DRB Project Number: 2024-010189 Hearing Date: 03-12-2025  
Project: 9601 Tierra Pintada Agenda Item No: 2

## **Development Facilitation Team (DFT) – Review Comments**

**Project No: PR-2024-010189 Date: 3/12/2025 Agenda Item: #2 Zone Atlas Page: (H-8, J-7, J-8)**

**Request: Subdivide Tract N-1 into two tracts**

MIREHAVEN PKWY

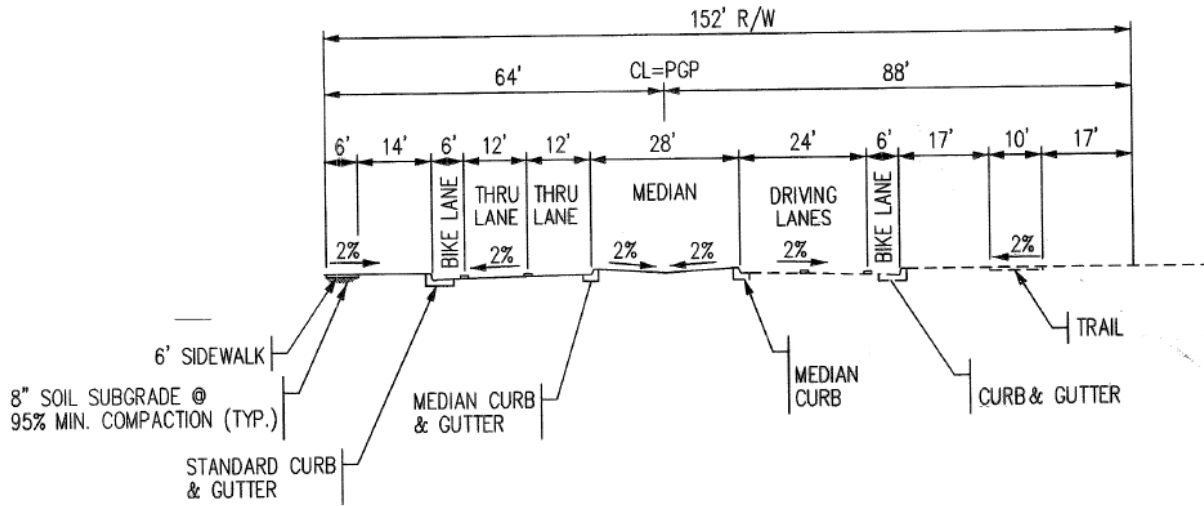
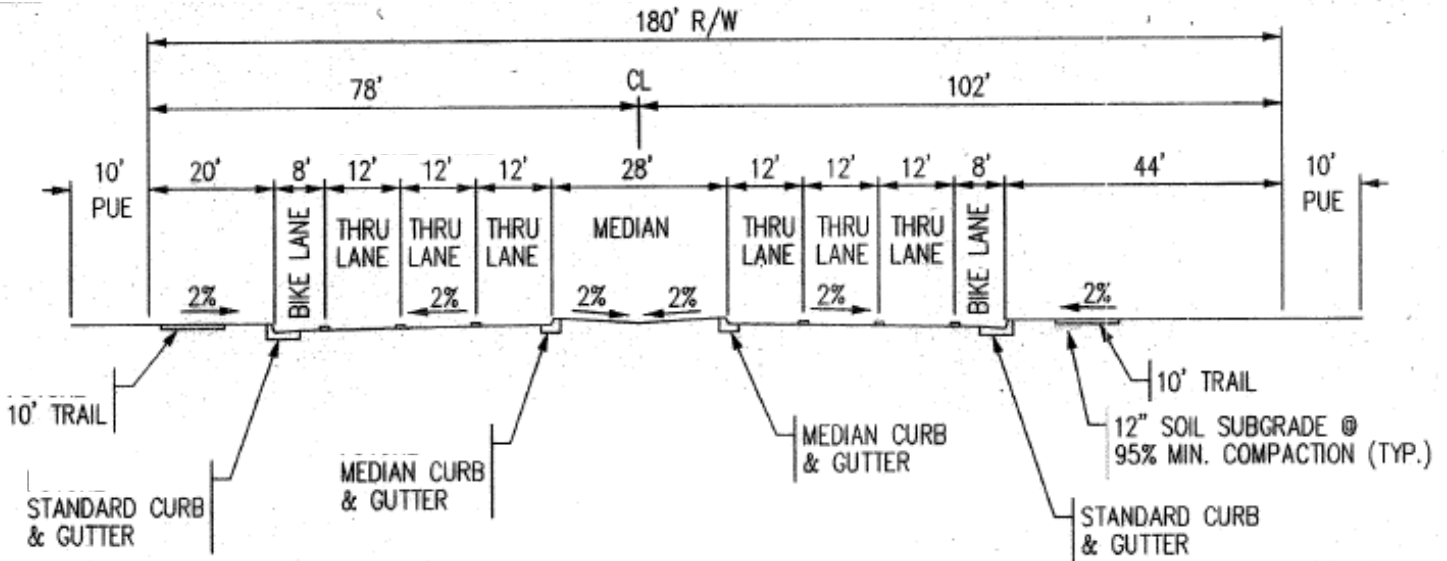
1. The cross sections provided show adequate sidewalk or trails for all roadways, though the landscape buffer for Mirehaven appears to be only 2' wide. Transportation defers to Parks and Planning if this is acceptable. No objections.
